Consultation Response from David Stainsby KC, Highways Development Management
2023/91261 land at, Alexandra Road West, Paddock, Huddersfield, HD3 4EX
Erection of two detached dwellings with garages, regrading of land and erection of retaining walls to form access and turning area from Lower Gate
Date Responded: 17/10/2023. Responding Officer: D. Stainsby Responding Ref: K5-1SW/5

This application is for the erection of 2 detached dwellings with parking and a new access on to Lowergate, a 30mph two-way single carriageway local link road of approximately 6.3m width with footways on both sides and street lighting present.

**1** PROPOSED SITE PLAN  
SCALE 1:100

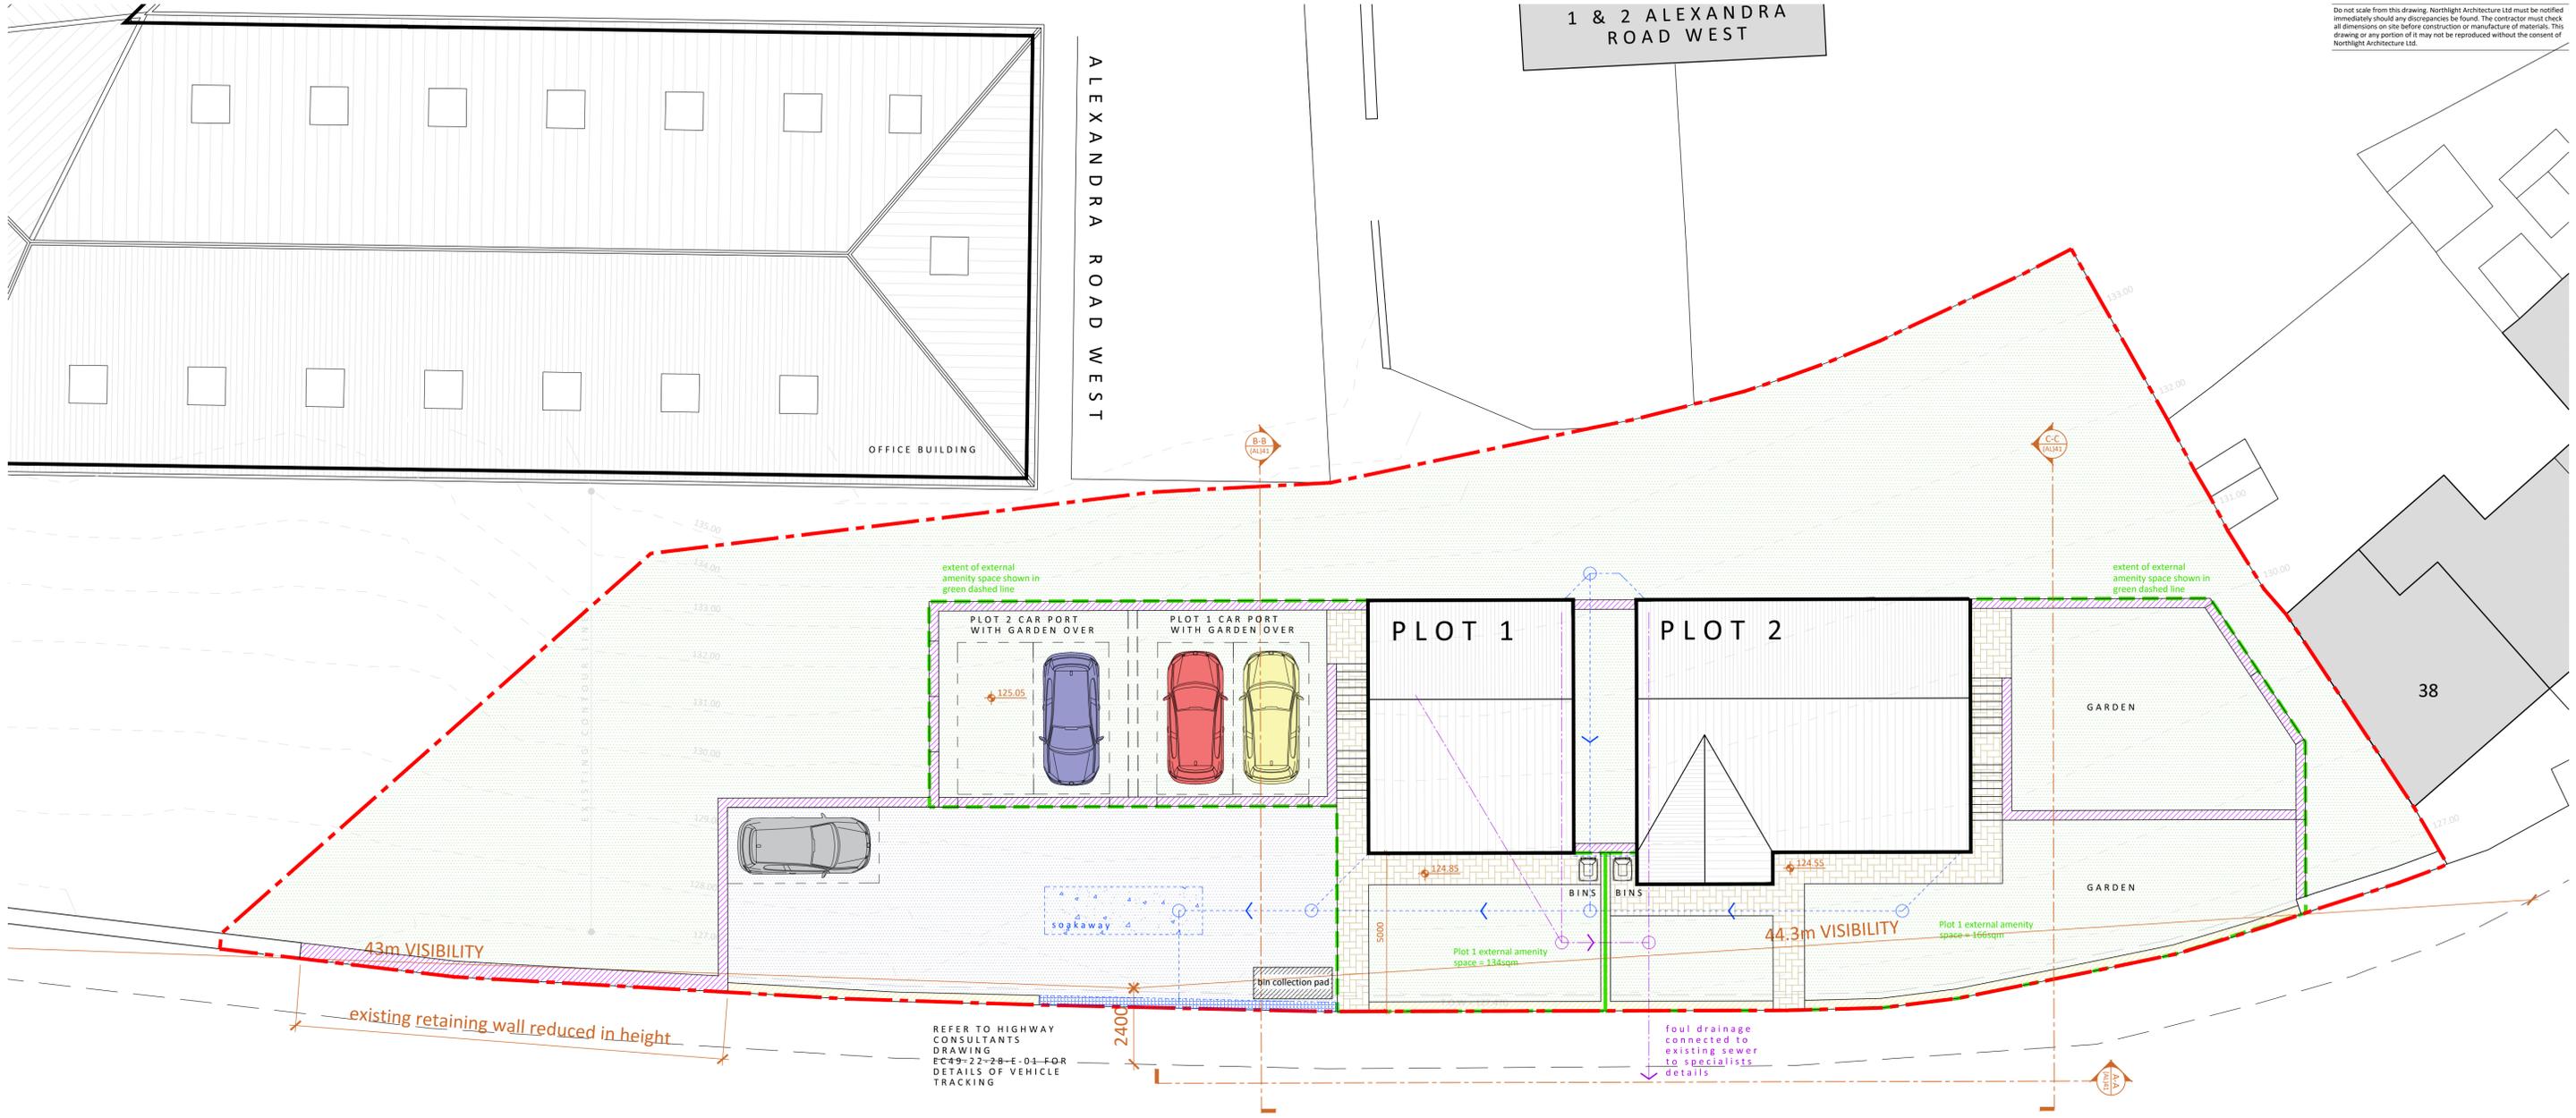
A swept path analysis to show that these vehicles can turn to leave the site in forward gear and details of waste storage and collection for both dwellings have now been provided.

The vehicular crossing shall not be brought into use until the existing telegraph pole and access chamber has been relocated to a location which must be agreed by the appropriate authority and does not obstruct vehicle turning movements into the proposed parking area.

The sightlines of 2.4m x 43m along Lowergate, as shown on the approved plan, shall be cleared of all obstructions to visibility exceeding 0.9 m in height and these shall be retained free of any such obstruction throughout the lifetime of the development.

Details of waste storage and collection for both dwellings have now been provided.

It should be noted that the collection of the bins from this location would be acceptable as there is an exemption from the double white centre-line TRO for municipal waste collection, however I've been advised by the Kirklees cleansing department that if there are issues with collecting adjacent to a solid white centreline, they may request that the bins are offered for collection from the car park, beyond the end of the double white centrelines
